RTA Ref: RDC 08M183 v2 SYD11/00201
Contact: Angela Malloch T 8849 2041
DoP Ref: MP08_0046

Transport
Roads & Traffic
Authority

MAJOR PROJECT APPLICATION FOR D'ALBORA MARINA, THE SPIT, MOSMAN

Figure 8: Aerial view of existing access point adjacent the sites frontage off Spit Road (Source: Google Maps 2011) and the proponent's proposed amendments to improve access (Source: Proponent's PPR)

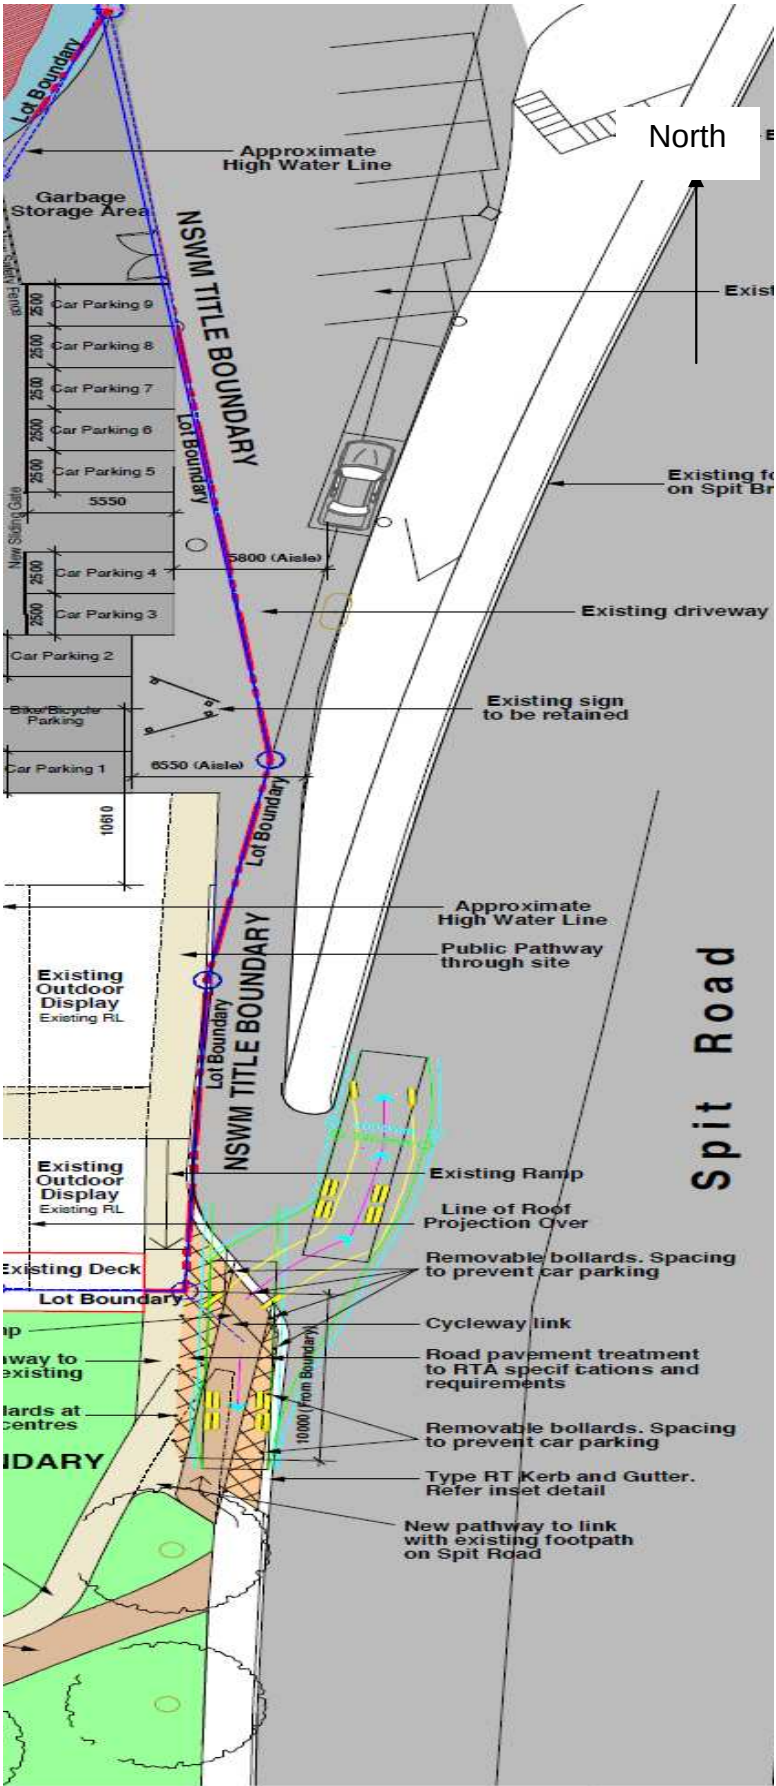
1. The RTA supports any changes to the existing access that would improve the safety and efficiency of the Marina's access point.

To adequately assess the proposed road improvements the RTA requires further detailed information of the proposed indented bay dimensions and how it fits in with the existing road reserve including the existing pedestrian pathway and cycle way.

The design shall take into consideration maintaining pedestrian pathways and allowing a safe point for pedestrians to cross adjacent to the Spit Road to walk continue along the Spit Bridge. The design shall also take into consideration maintaining a safe interface for cyclists continuing past the Marina Building and under the Spit Bridge.

2. The RTA also requires an assessment of the sight distance for vehicles entering and exiting the site, if a 12.5 metre vehicle is parked in the indented bay.
3. The RTA requires further information on how waste disposal will operate, i.e. how will waste from the Garbage Storage Area be transported to the proposed indented bay for removal.
4. The RTA requires information on expected number of service vehicles per week and vehicle type.
5. The RTA requires confirmation on whether boat trailers will be used to transport boats to the Marina.
6. It is unclear whether the proposed indented bay will be constructed by the proponent or Council. The RTA requires this information to be able to respond accordingly to the Department of Planning.
